Ribble Valley Borough Council
Housing & Development Control

Application no: **3/2022/1187**

Address: **Land south of Lower Road Hothersall Longridge PR3 2YY**

Proposal: **Erection of three business units (Class E) comprising three new buildings with access, parking and provision of secure compounds.**

**Land off Blackburn Road, Longridge – Site Layout Plan 2**

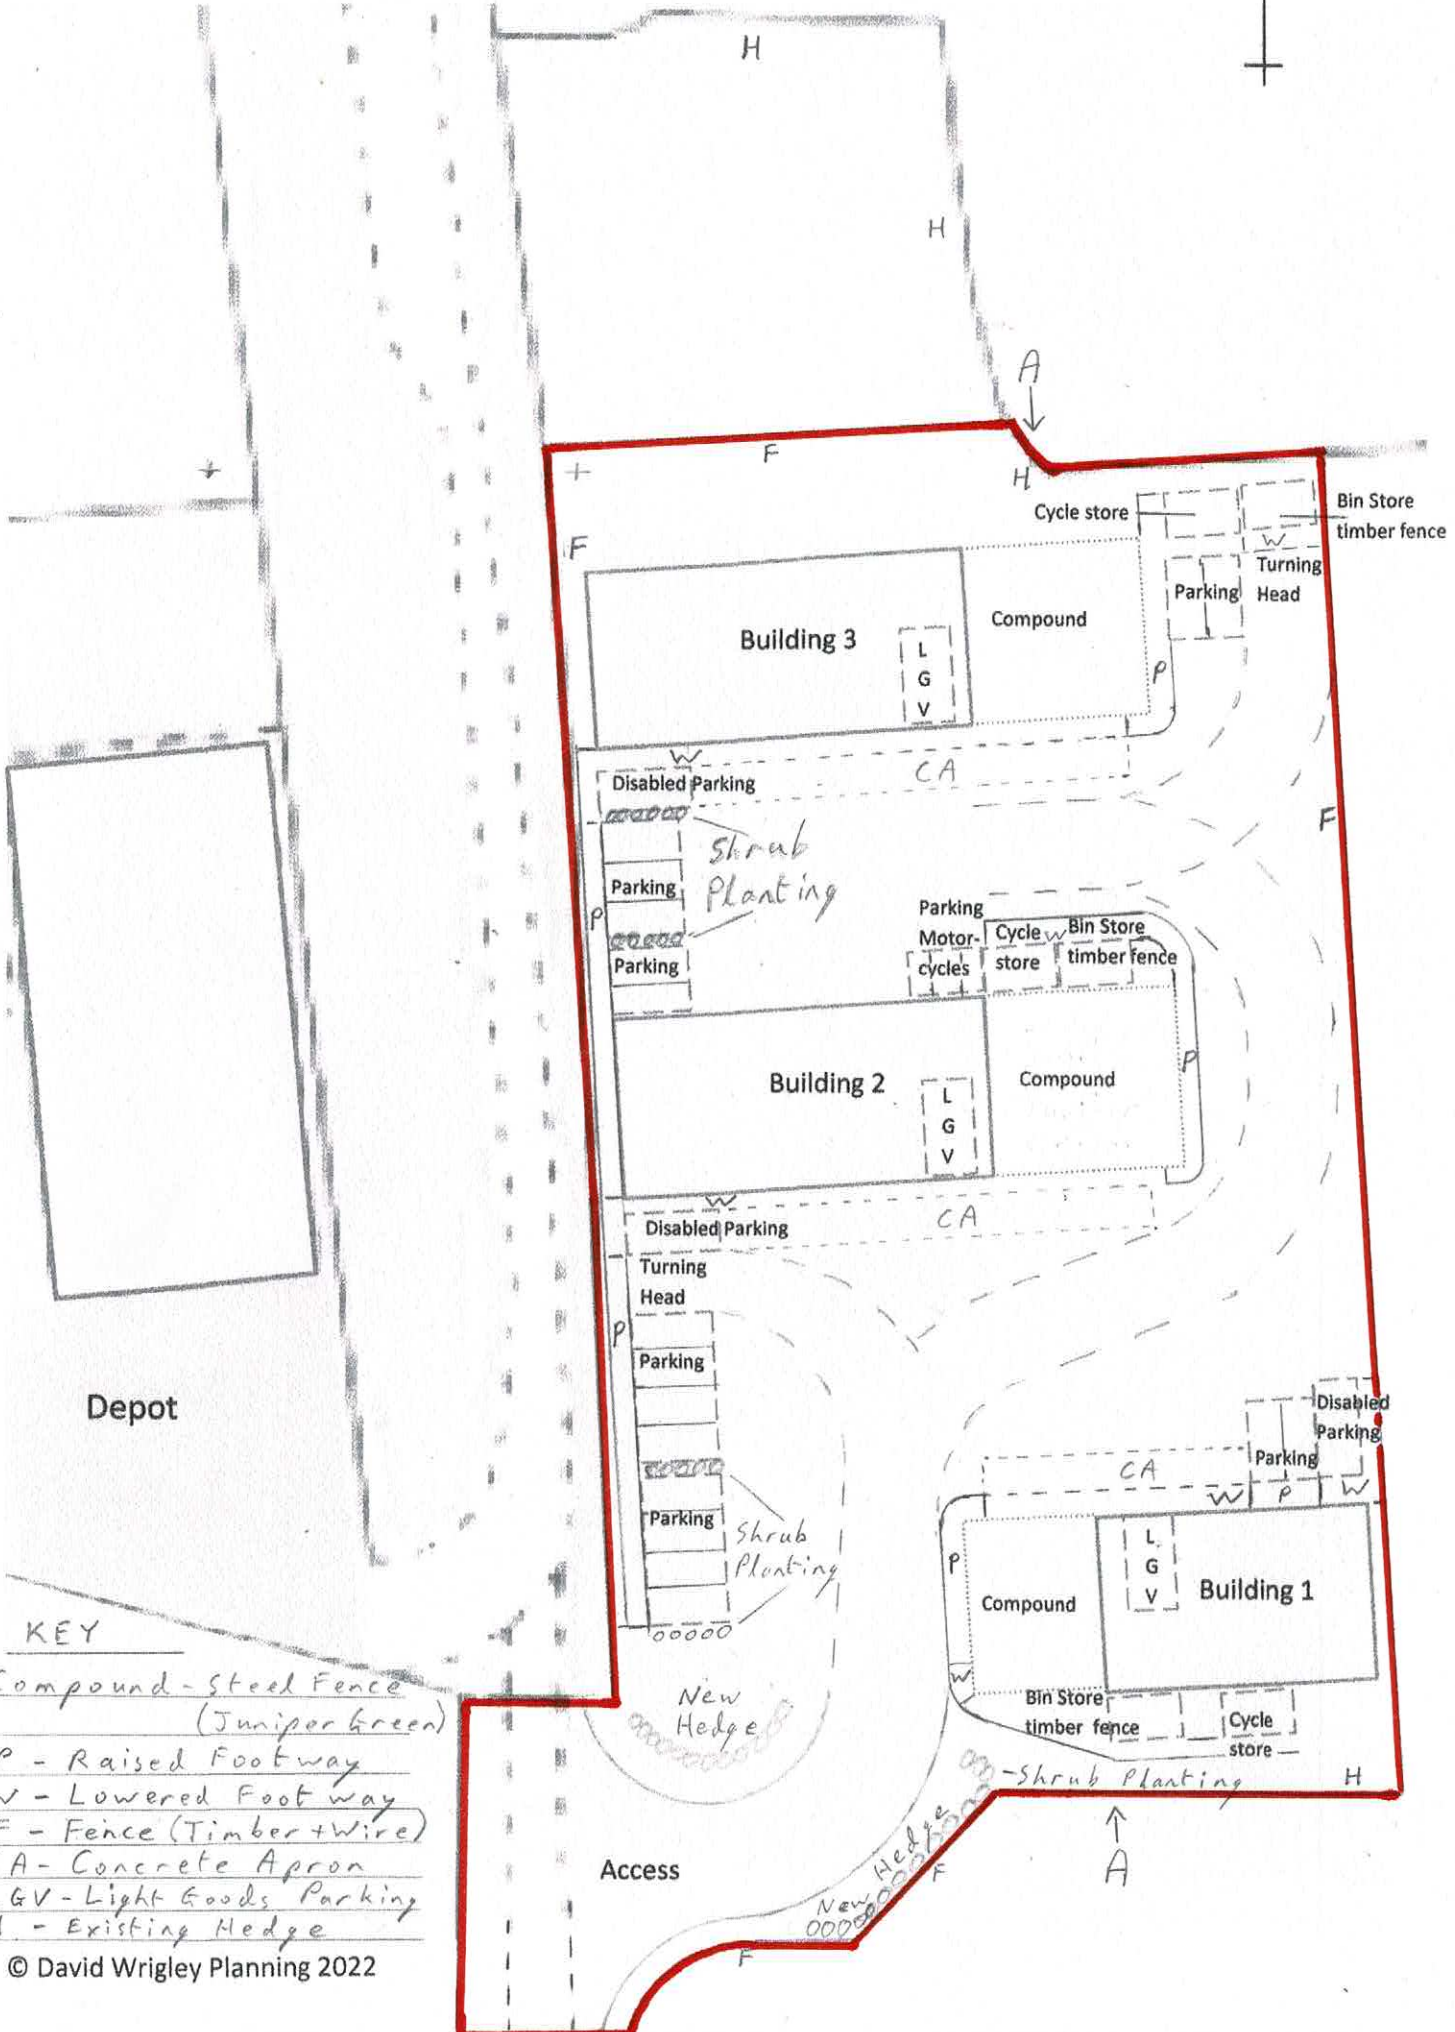
The LHA have reviewed the drawing titled "Site Layout Plan 2" and require further amendments to be made before the internal layout is at an acceptable standard. This is because of the following which will be discussed below:

The LHA are aware that an 8m wide access located off the existing access track will be provided to serve the site and it will have a 16m kerb radii. Before the LHA can comment on the suitability of the internal access, the internal carriageway serving the three units and the three provided turning areas, a swept path drawing of a 12.5m long rigid vehicle is required showing that the internal layout including the turning areas are safe and suitable for such movements.

The LHA also welcome the provision of internal footways that will allow pedestrians a segregated route from the parking area to the Units. However, no footways have been provided at the internal access and there are no footways which serve Building 1. Therefore, further amendments are required on a revised site plan.

The LHA require the amended internal footways to link to the requested footways located along the access track, to ensure that pedestrians have a segregated facility in and out of the site.

The LHA have reviewed the drawing titled "Site Layout Plan 2" and aware that the site will provide 17 car parking spaces for the 3 Units. However, the quantity of parking does not comply with the parking guidance as defined within the Joint Lancashire Structure Plan which requires the site to provide 26 car parking spaces given the internal floor area of the proposal. Therefore, further amendments are required.

The LHA inform the Agent that each Unit should have access to one electric vehicle charging point and a disabled space. The Agent has also provided each unit with a cycle storage facility which provides access to 7 cycle stands which is welcomed by the LHA.

Furthermore, as shown on the drawing, each Unit will have access to an internal Light Goods Vehicle (LGV) parking space. The LHA require a swept path drawing showing that the space is usable for an LGV before commenting on its suitability. The LHA do highlight that they are concerned that LGVs will have to reverse out of the space when exiting the Unit, which could lead to potential conflicts arising should other vehicles use the internal carriageway simultaneously.

Given that the largest vehicle servicing the units will be a 12.5m long rigid vehicle, a servicing area for each Unit is required which can accommodate these movements. Each servicing area should have a facility to ensure that these vehicles can exit the area in a forward gear, and this should be supported by a swept path drawing.
